Re: Advice on Environmental Impact Statement (EIS) – BRITTON STREET MULTI-LEVEL WAREHOUSE – 15 – 21 BRITTON STREET AND 28 – 54 PERCIVAL ROAD, SMITHFIELD (SSD-67368956)

Fire and Rescue NSW (FRNSW) acknowledge correspondence received on the 12 November 2024, requesting advice on the EIS for BRITTON STREET MULTI-LEVEL WAREHOUSE – 15 – 21 BRITTON STREET AND 28 – 54 PERCIVAL ROAD, SMITHFIELD (SSD-67368956). FRNSW have reviewed the EIS with particular focus to 3.2 Project Overview, along with Appendix 4 Architectural Drawings.

TITLE	WAREHOUSE PLAN - GROUND
DATE	22.10.2024
SCALE	1:750 @ A1 1:1500 @ A3
PROJECT NO.	22144
DWG NO.	DA102
REVISION	20

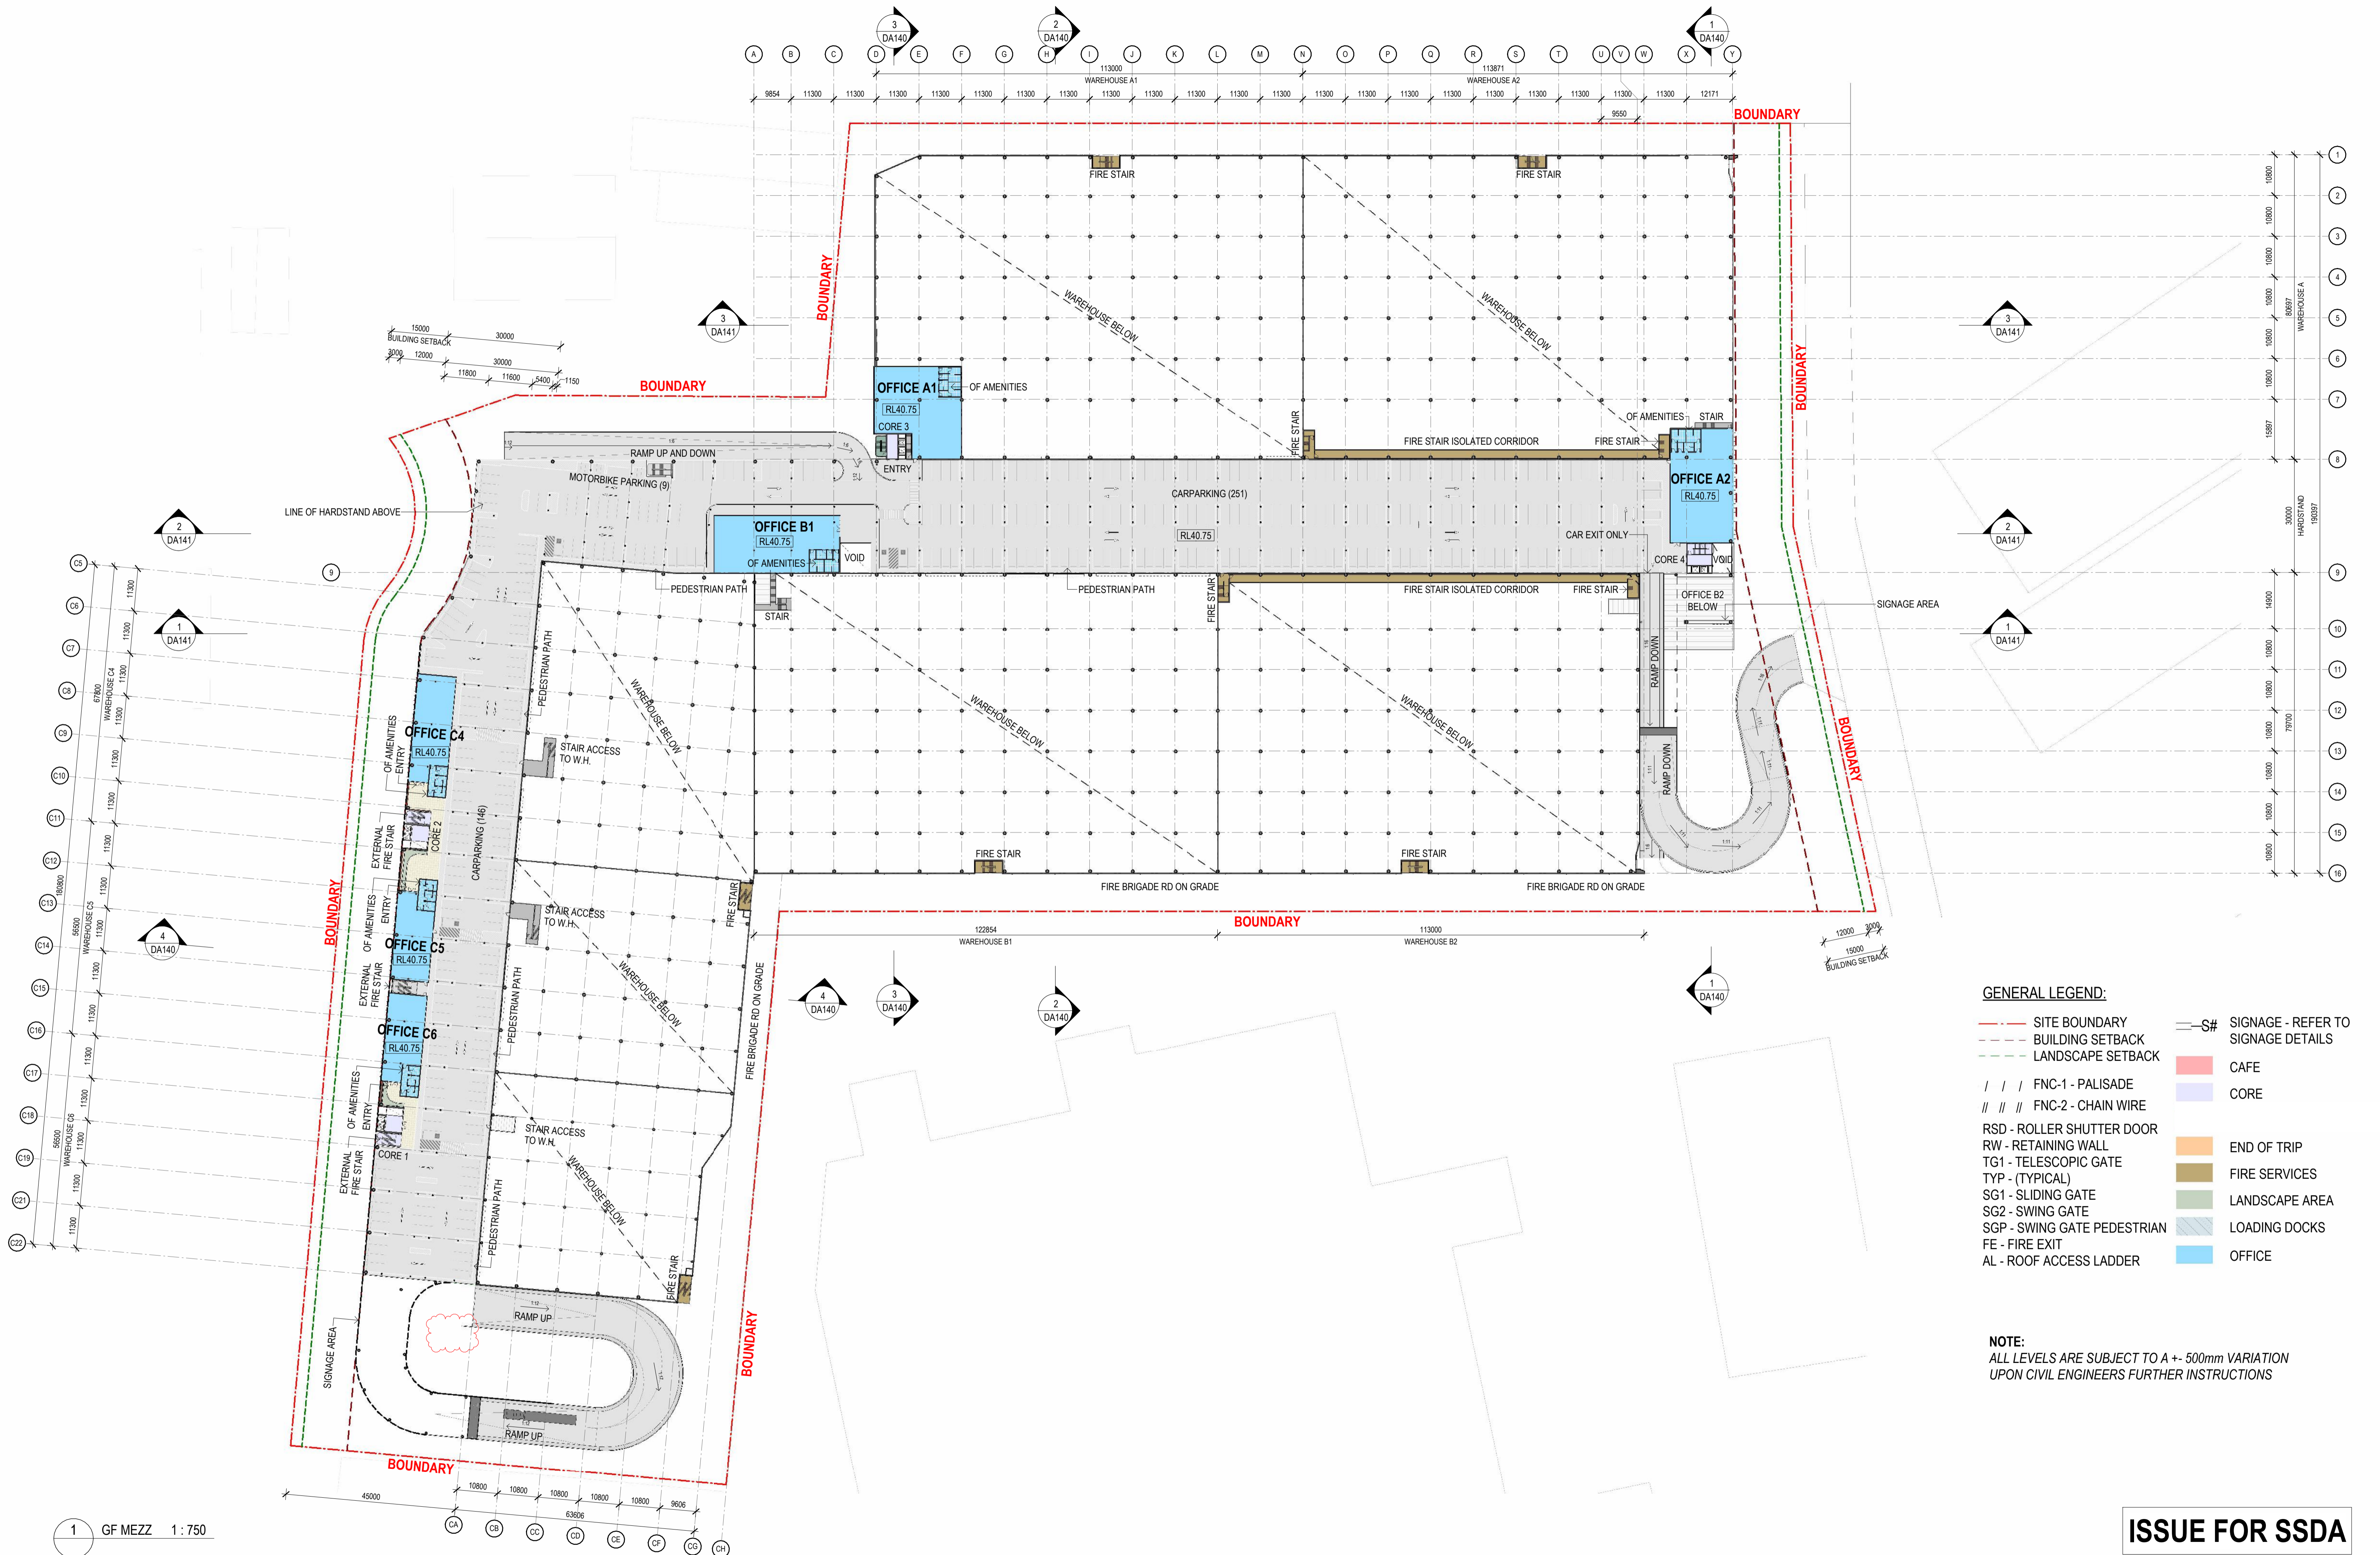
1. Compliance is demonstrated with FRNSW fire safety guideline - Access for fire brigade vehicles and firefighters. Perimeter Vehicle Access must be provided at ground level and of an obvious and appropriate hardstand material.¹
2. It is the experience of FRNSW that the water demand for fire infrastructure servicing a development of this scope is unlikely to be supplied by mains water alone. FRNSW recommend that suitable design considerations are considered for the placement of tanks and other firefighting infrastructure if required.
3. That thorough analysis of the Fire Brigade Intervention Model is conducted to ensure that appropriate water supply is provided for hydrant and sprinkler systems.
4. Implement the applicable provisions of AS2419 Appendix C (informative).
